From: Sue Howell <Sue.Howell@arun.gov.uk>
Sent: 11 February 2021 15:16
To: Planning.Responses <Planning.Responses@arun.gov.uk>
Cc: James Cross <James.Cross@arun.gov.uk>
Subject: FW: Planning Consultation on: BN/153/20/PL

Response to Planning Application

Application ref: BN/153/20/PL

Description: 44 No. dwellings & associated infrastructure. This site falls within the BEW Strategic Site, CIL Zone 1 (Zero Rated).

Drawing Title
Proposed Site Layout

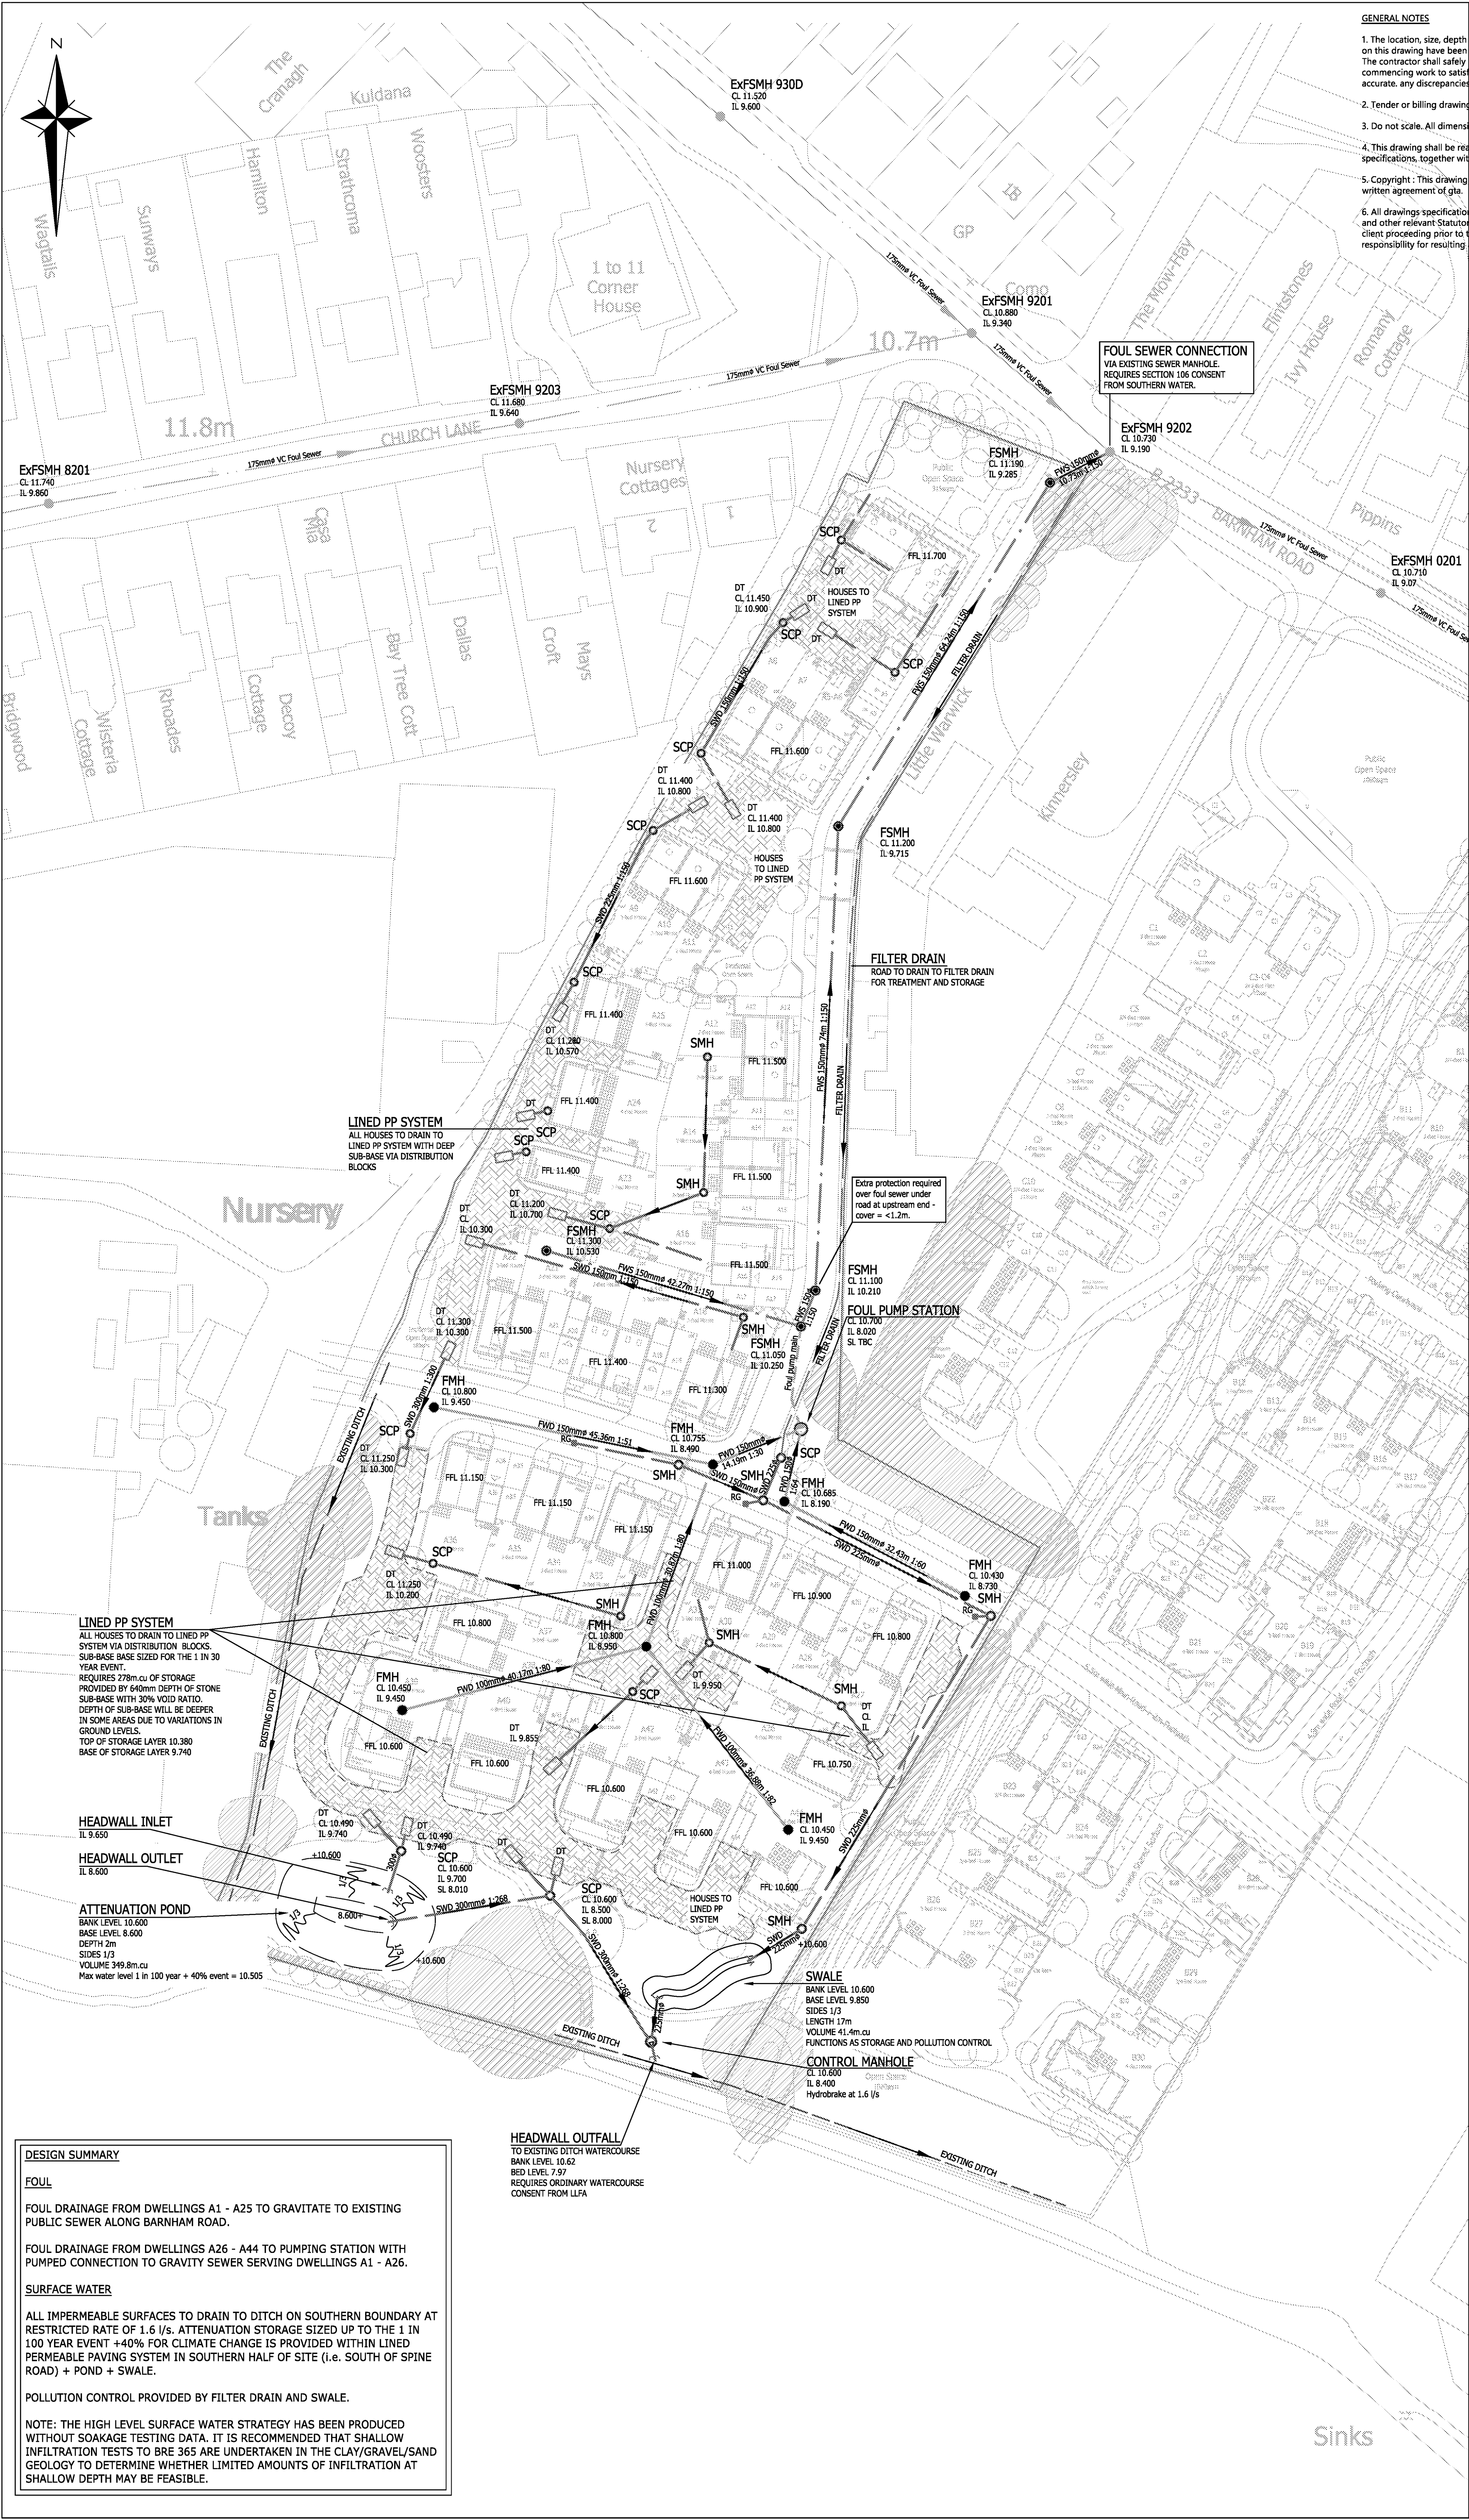
The proposed site layout PL-005 Rev C, Proposed Landscape Strategy sheets 1 & 2 LAC-EAS-LS 001/002 are indicative at this stage, but will need to provide further detail. Quality landscape planting will be required to enhance the setting, to create sense of place, desirable living areas and distinctiveness within the plot areas. A design intent for tree planting to retain and enhance existing tree presence associated with the site, and not just limit it to the boundaries will be fundamental to the scheme. Planting within the boundaries will improve the species composition and diversify the age structure, woodland belt deepening will improve screening properties to neighbouring dwellings and beyond.
